From: Will Pearce
Sent: 13 March 2017 16:49
To: Stephen Thorpe
Subject: FW: 56, High Street, Bognor Regis - former Store Twenty One. Structural feasibility study.

Subject: 56, High Street, Bognor Regis - former Store Twenty One. Structural feasibility study.

Peter Willmott CEng; FIStructE
Consultant
Archibald Shaw
One Little London
Chichester
West Sussex PO19 1PP

proposed
street elevation (56 high street)
scale approx 1:200

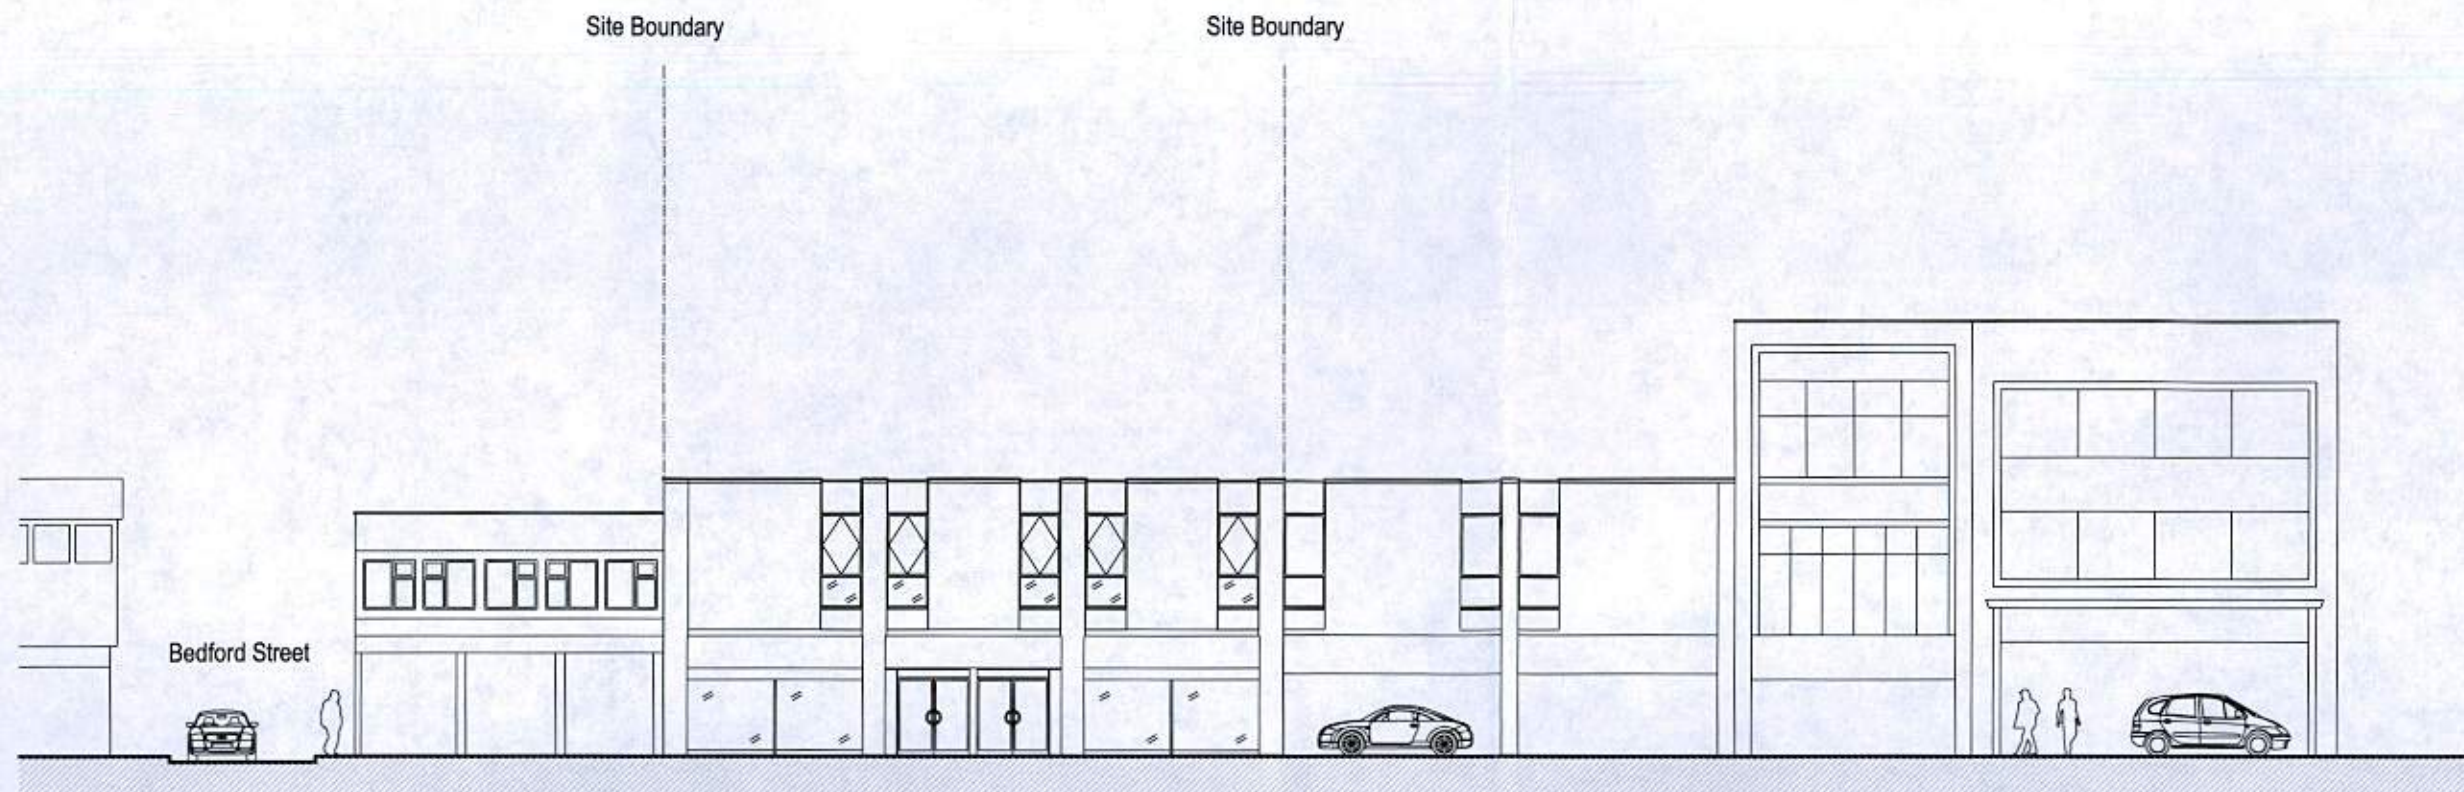
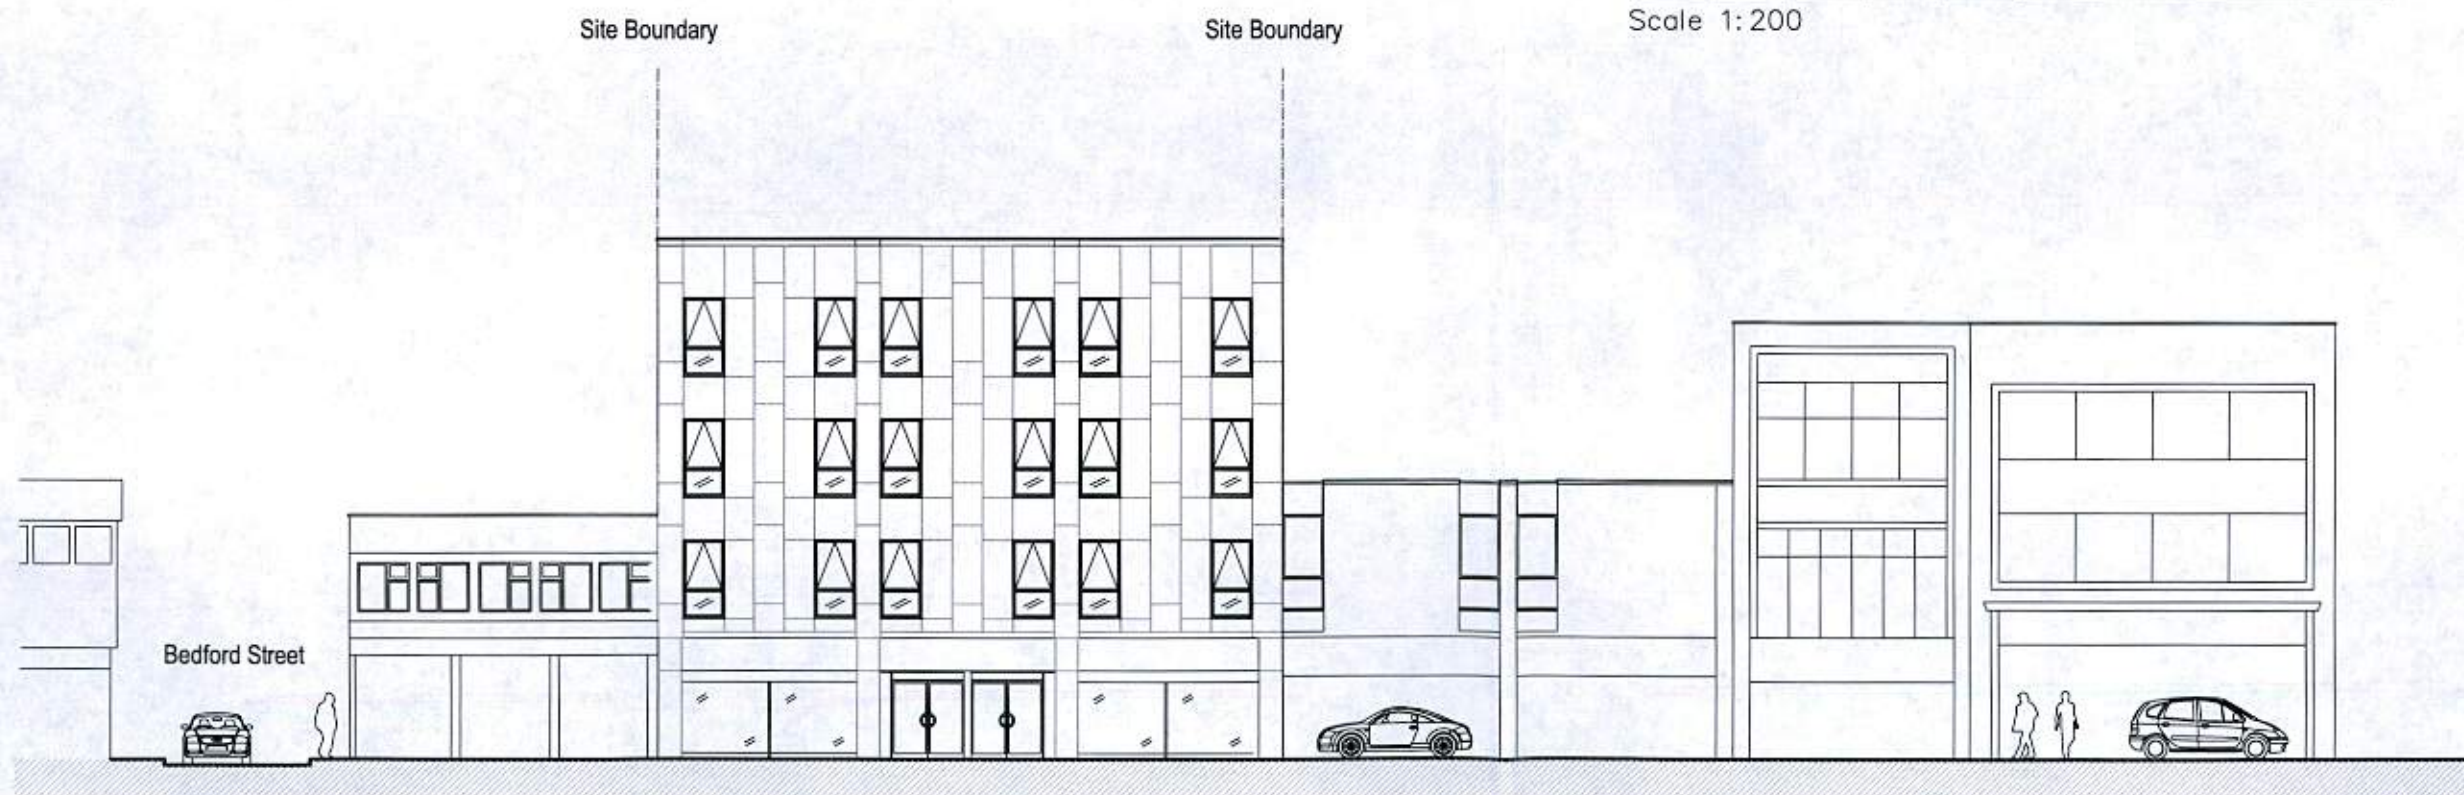
I conclude that insofar as the existing frame and foundation components are concerned there is sufficient capacity to permit the addition of two storeys specifically for domestic accommodation. There are further considerations and design provisos as follows –:

Building stiffness - there will be an increase of horizontal wind loads to the existing frameworks which we will need to consider. The retention of masonry wall components at ground floor may be necessary for the desired building rigidity but subject of further analysis.

Drawing  
**Proposed Cross Section**

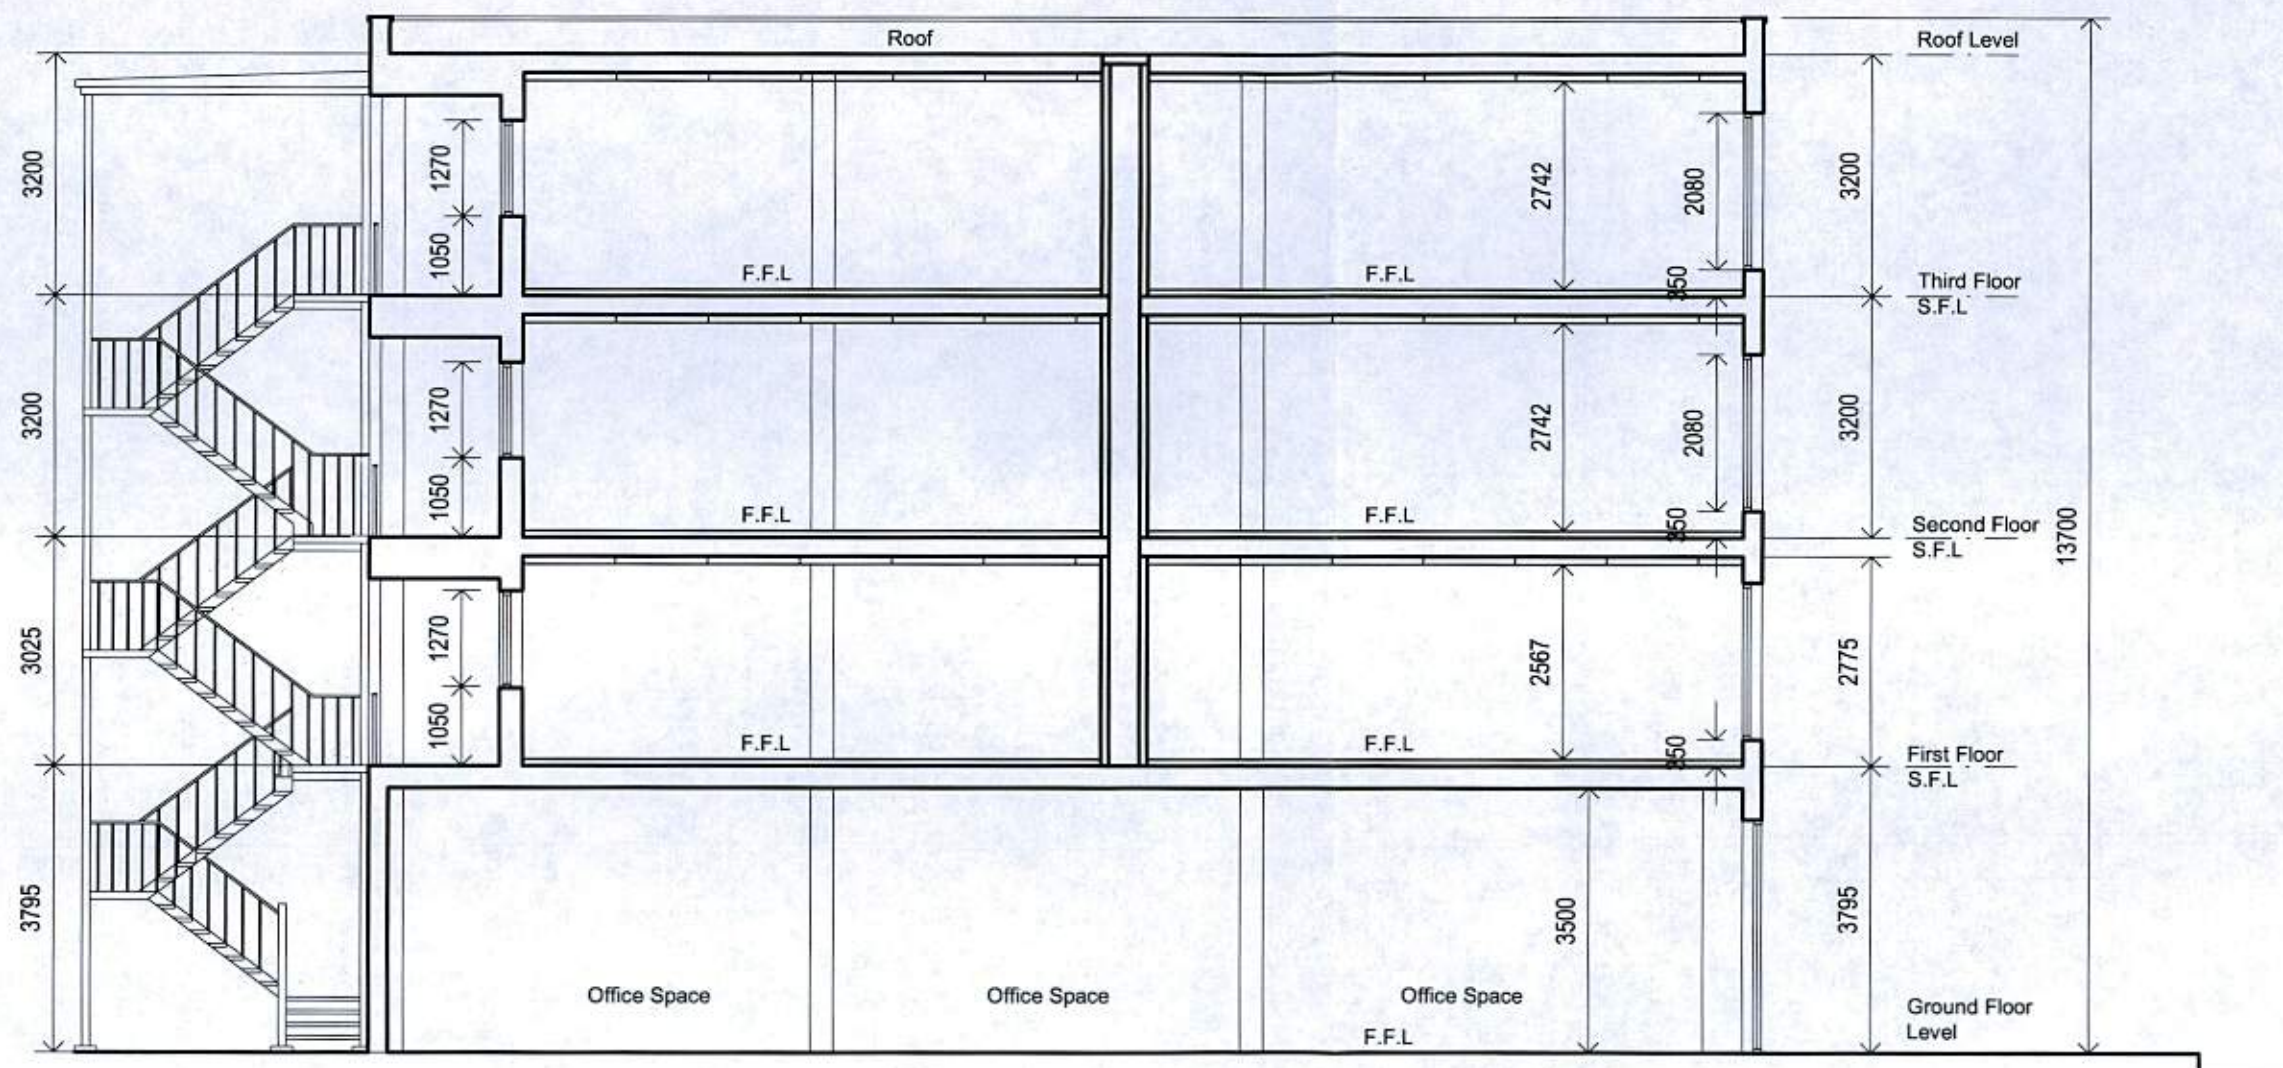
Existing 1st floor adequate by inspection since new loads will be less than existing. You will need to develop the specification for this being a party floor and this may involve some further assessment. The existing stairwell needs infilling.

Existing roof structure – there is a small increase of load to this structure estimated currently at 0.05Kn/Sq Metre but only on the basis that we can remove existing roof coverings and replace with lightweight floor surfacing. Given this then in my opinion the roof structure can be retained for use as the second floor. The specification will need to provide for this to be a Party Floor.

New 3rd floor and roof – we need the new floor and roof to be lightweight. The floor could be timber joisted to Party Floor standard and roof preferably metal deck or similar. The whole could potentially be an offsite package in timber or metal frame. All loads must be directed back to the current column positions and this will demand a column and beam frame designed for lateral wind loads.

Rear wall 1st to 2nd – this will be lightweight but will set up a line load on the existing first floor. This is something we will address as the design is developed but may demand some local enhancement. New upper floor walls will be supported on frameworks but must be lightweight.
